**Job Name:** Bicester Gateway Phase 1B Residential  
**Job No:** 46463  
**Note No:** TN005  
**Date:** 28/01/2019  
**Prepared By:** Francois Chate  
**Subject:** **Review of the revised Transport Assessment dated 24<sup>th</sup> December 2019 in support of Albion Scheme (ref:19/01746/OUT and 19/01740/HYBRID)**

- 1.6. This note provides a review of the 24<sup>th</sup> December 2019 'revised' Transport Assessment (referred to below as the Revised TA). This note refers to paragraphs in the Revised TA where relevant.

Figure 6 – Proposed Pedestrian Route

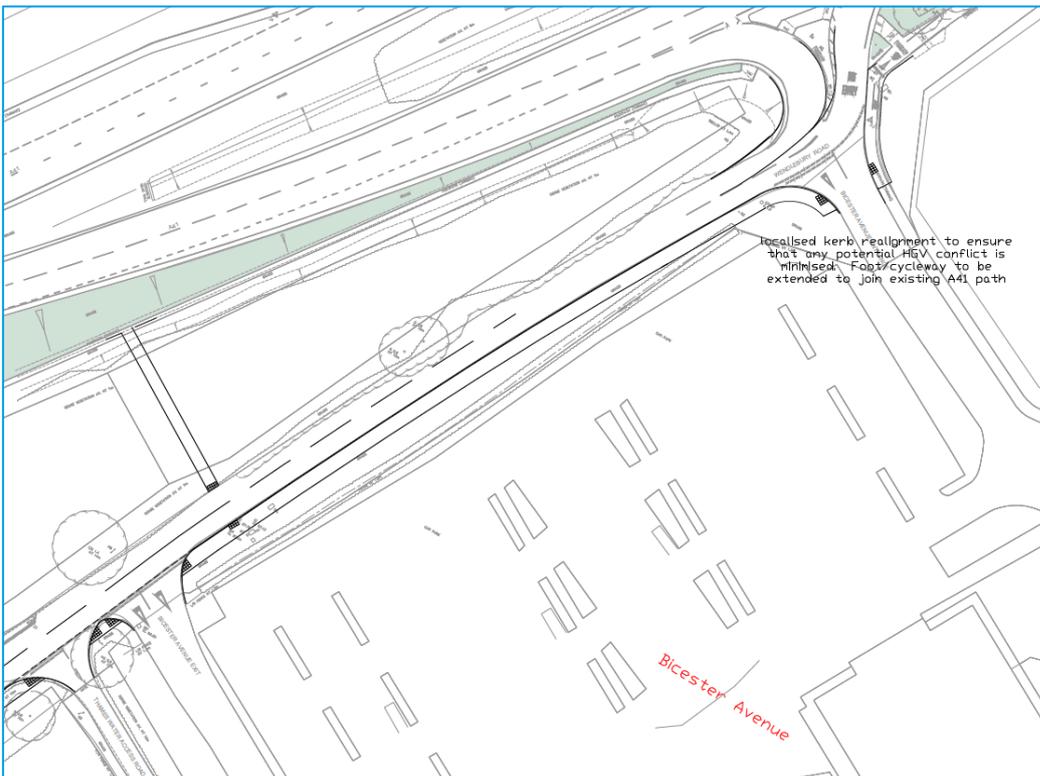
- There is a doubt as to whether Albion Land would have the ability to deliver the convoluted and substandard pedestrian and cycle facilities they put forward within their TA. The Revised TA provides clearer drawings illustrating the proposed footway/cycleway and the text of the Revised TA clarifies that the proposed facility 'would be 3.0m wide (narrowed to 2.5m minimum where highway boundary constraints dictate)' (see paragraph 5.1.2). Unfortunately, the scheme drawings provided in Appendix J of the Revised TA do not provide any dimensions, therefore it is not possible to verify where the narrow sections of the proposed facilities would be. The Revised TA refers to a Road Safety Audit of the proposed scheme that highlights the need for the provision of a guardrail along the proposed footway/cycleway for the section adjacent to the application site boundary. The provision of a guardrail would reduce the effective width of the footway/cycleway proposed and potentially lead to a facility 2.25m wide in places, which would be substandard. Substandard provision for pedestrians and cyclists should not be deemed acceptable by OCC.

- The initial review highlighted the lack of consideration for cyclists travelling from Wendlebury Road (south) along the NCR in the original proposals. This seems to have been addressed in part with the revised scheme providing a facility for cyclists travelling southbound to re-join the carriageway. However, no facility is proposed for cyclists travelling northbound.
